21 August 2025

The Secretary
NSW Department of Planning, Housing and Infrastructure

SSD-81434988 Alspec Warehousing Facility

Drawing Title:
 GENERAL ARRANGEMENT PLAN - WAREHOUSE
 Date: 23/05/25 Sheet Size: A1 Scale: 1:750
 Drawing Number: 14291_DA010 Inset: PS

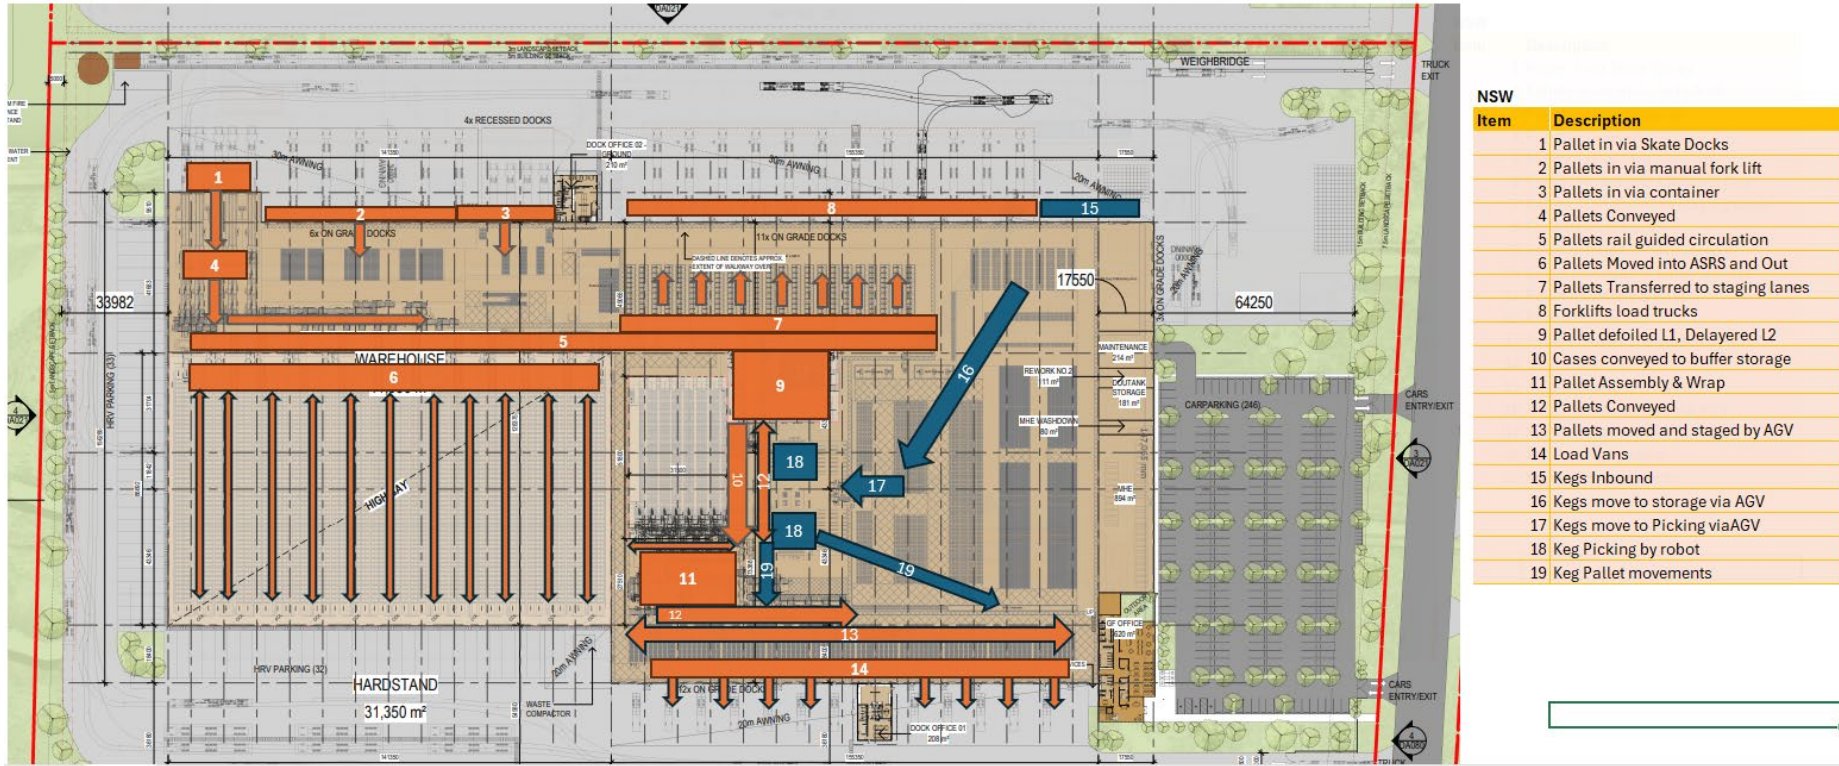
From a review of the Architectural Plans there does not appear to be any provision made for the required distribution / padmount substation on the site.
